STATE OF NORTH CAROLINA
DEPARTMENT OF TRANSPORTATION

October 22, 2007

SUBJECT: **Permit Modification Request for TIP I-2511CB**, I-85 Improvements from North of SR 1002 to North of SR 2120 Near the Town of Spencer in Rowan County, State Project No. 8.1631503, Tip No. I-2511CB.

PROJECT: 8J63503 (I-25/ICB)
I-85 FROM NORTH OF SR 1002 (BRINGLE
FERRY RD.) TO NORTH OF SR 2120
(LONG FERRY RD.) NEAR SPENCER
SHEET 4 OF 35
REVISED 8/10/05

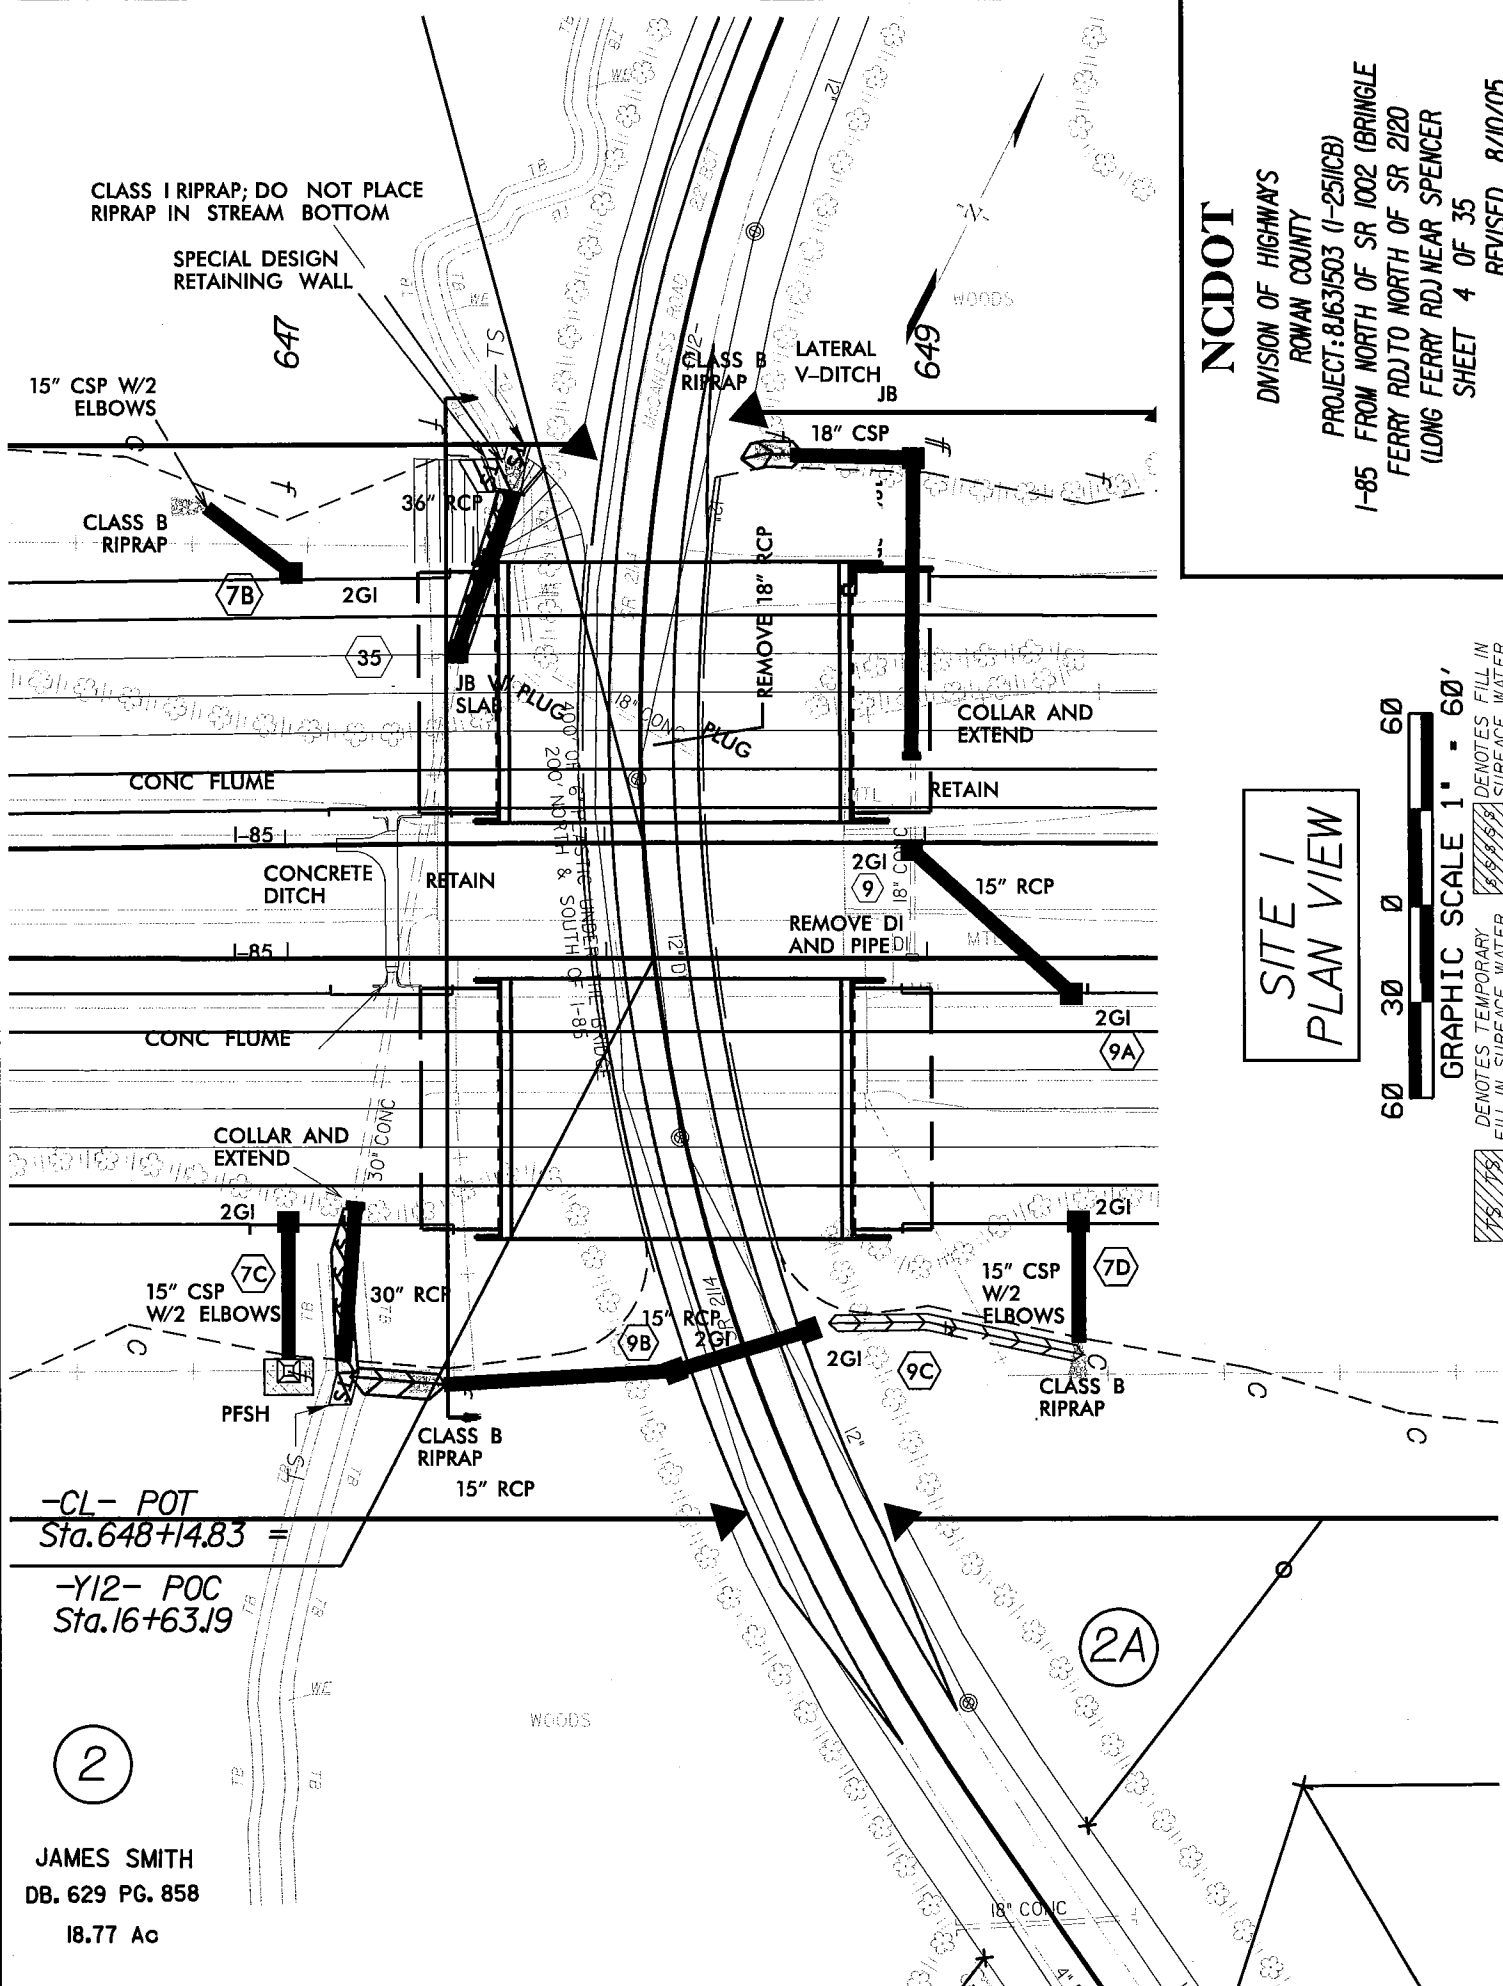
The design for the existing RCP extension in UT to Town Creek is being proposed for modification to eliminate the headwall previously permitted due to the amount of blasting of bedrock in the stream channel that would be required to construct the footing for the headwall. The additional 13 linear feet of permanent stream impact is from the proposed extension of the RCP. The quantity of temporary stream impacts associated with the installation of the pipe extension is less than was associated with the headwall, although the reportable quantity (<0.01 acre) remains unchanged. The area of temporary impact will be shifted 13 feet further downstream to the end of the proposed RCP extension.

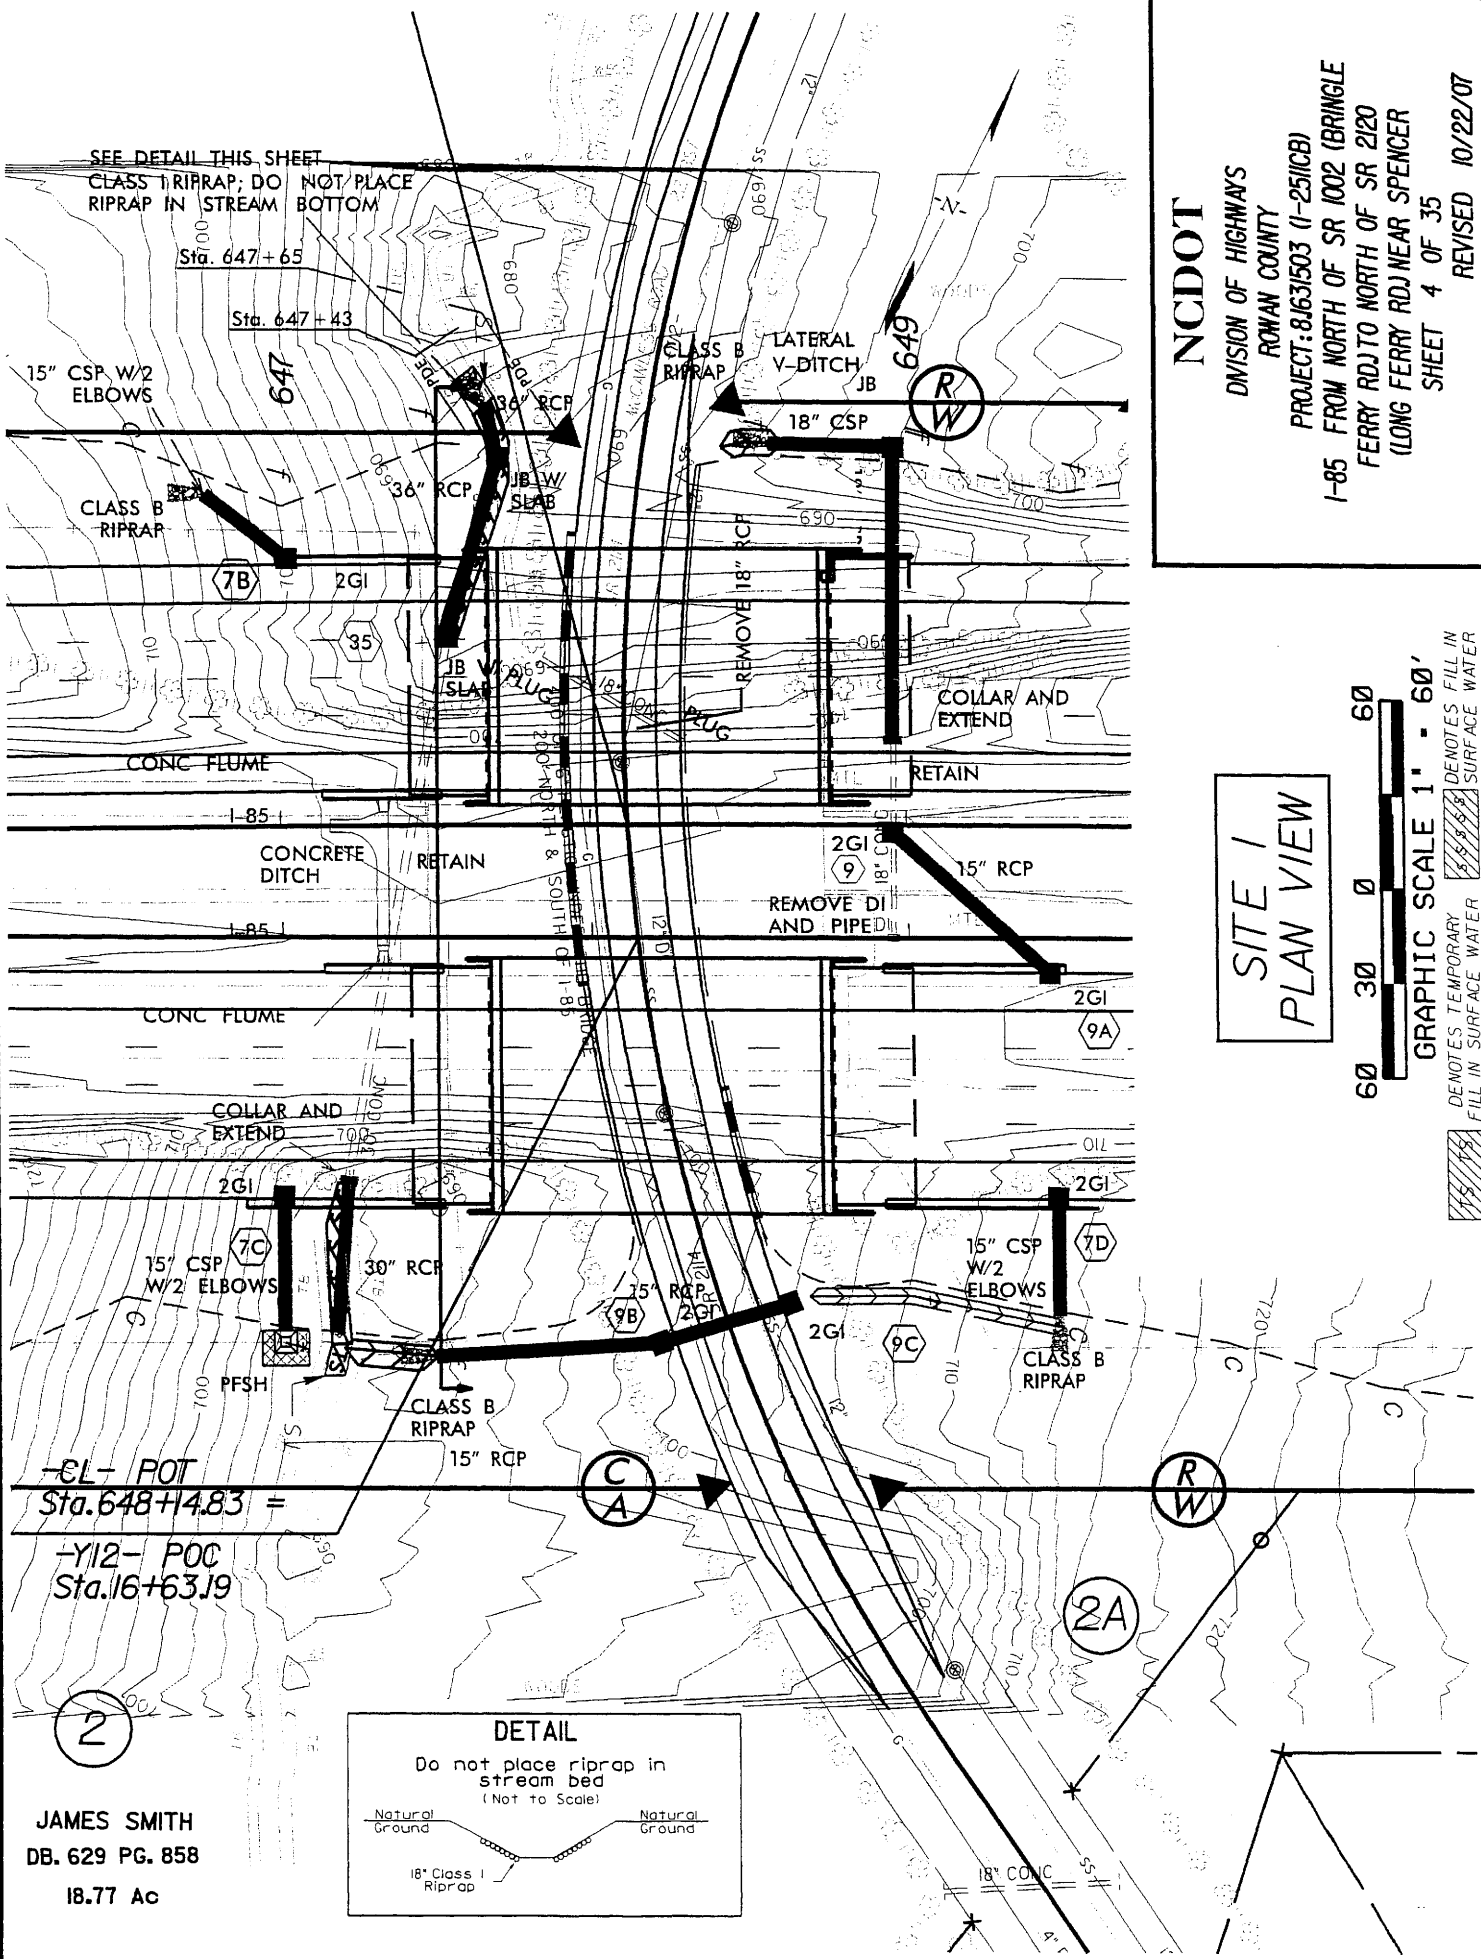
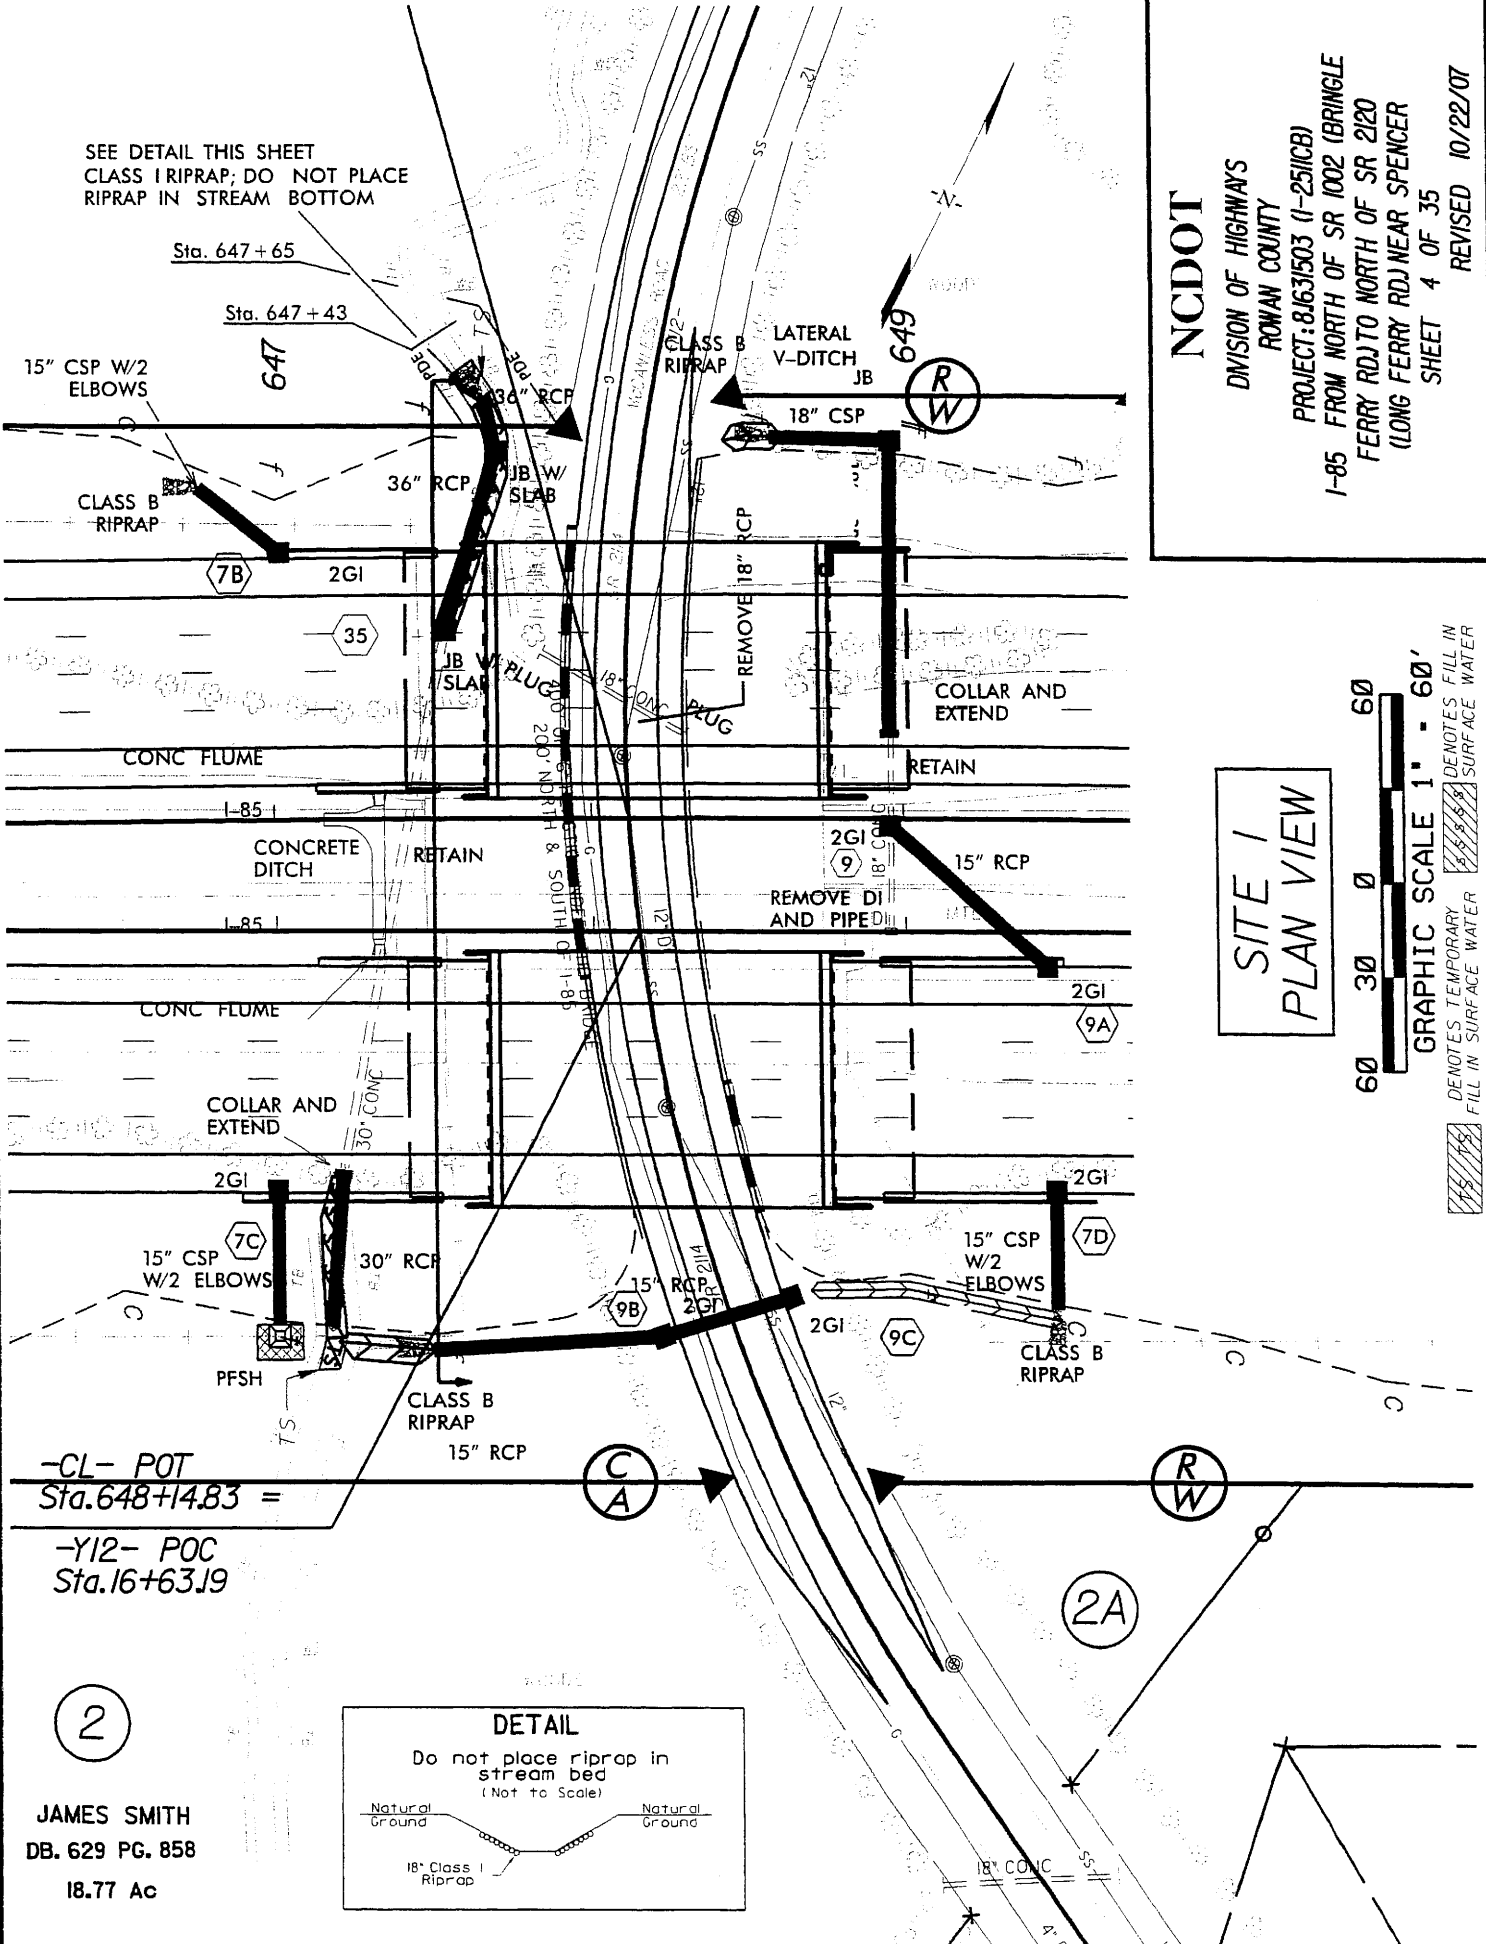
Site 1, Sheet 4 of 35

Station 647+50 – L – (LT/RT)

Authorized Impact: 102 linear feet permanent stream and <0.01 acre of temporary stream impacts;

Proposed Impact: 115 linear feet permanent stream and <0.01 acre of temporary stream impacts.

Impact change: increase of 13 linear feet of permanent stream impacts (which requires mitigation through EEP).
